Ribble Valley Borough Council
Housing & Development Control

Application no: **3/2022/0842**

Address: **Beacon Cottage Commons Lane Balderstone BB2 7LN**

Proposal: **Proposed erection of two holiday chalets on land adjoining Beacon Cottage.**

Drawing No: Garnett.999.3210.01

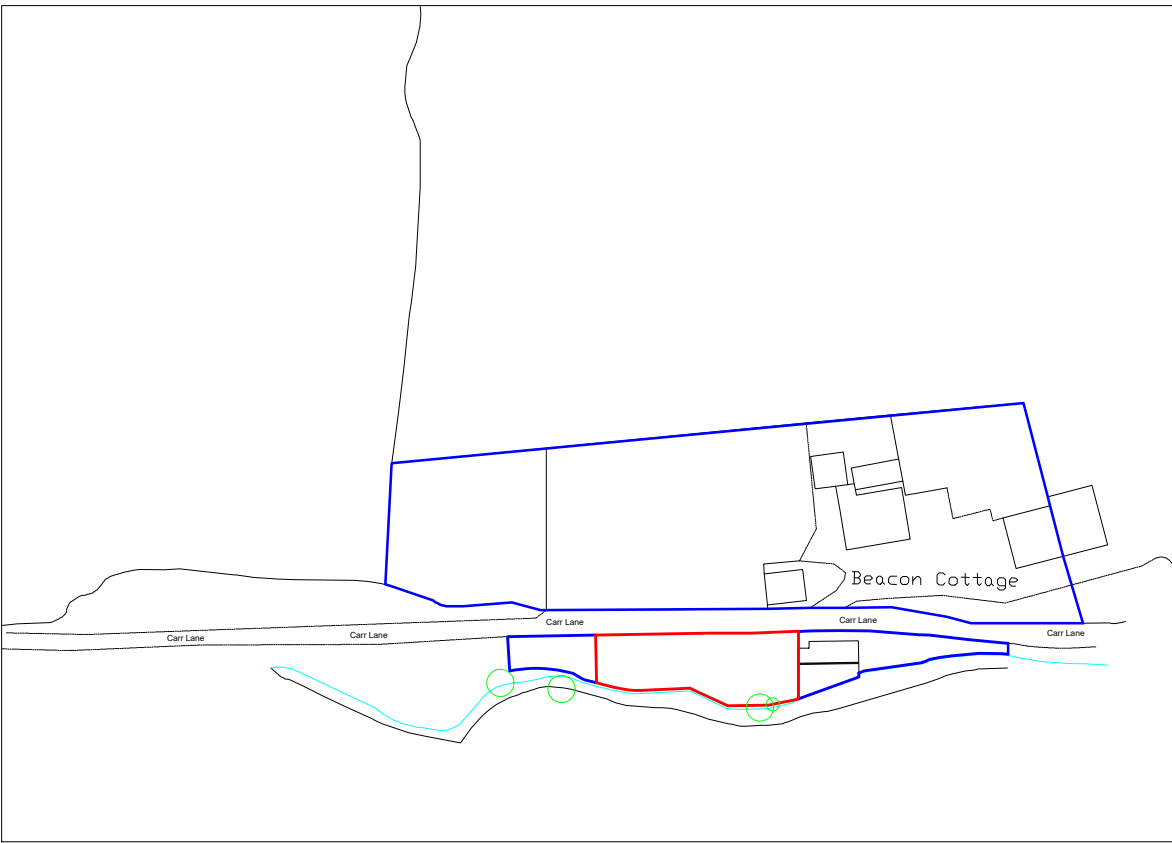
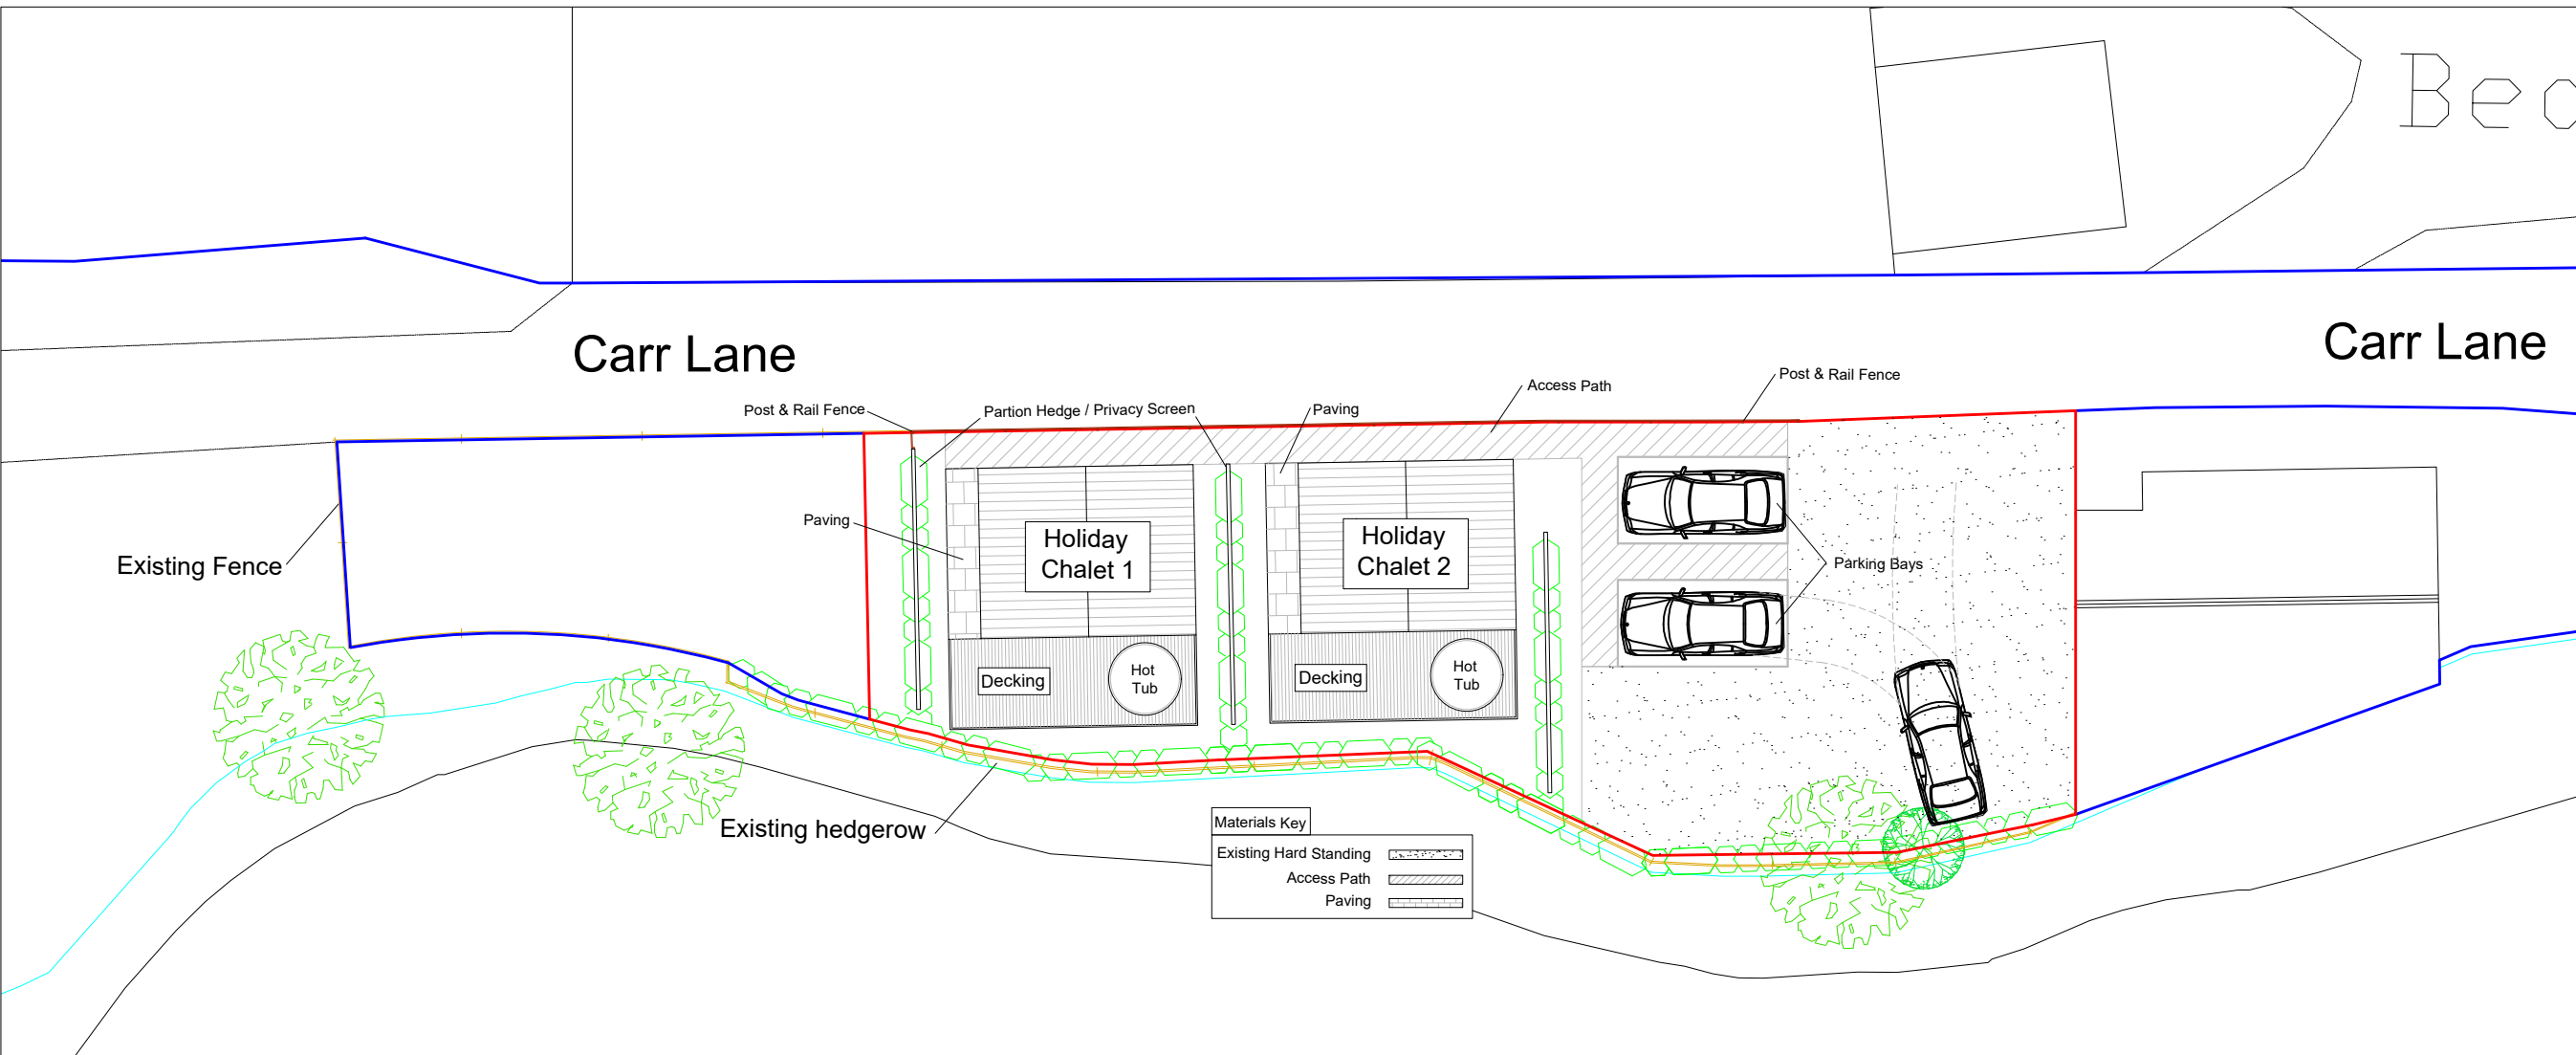
The LHA have reviewed GHA drawing number 999.3210.01 titled "Existing Site Plan, Proposed Site Plan and Vacation Plan" and are aware that the site complies with the parking guidance as defined in the Joint Lancashire Structure Plan.
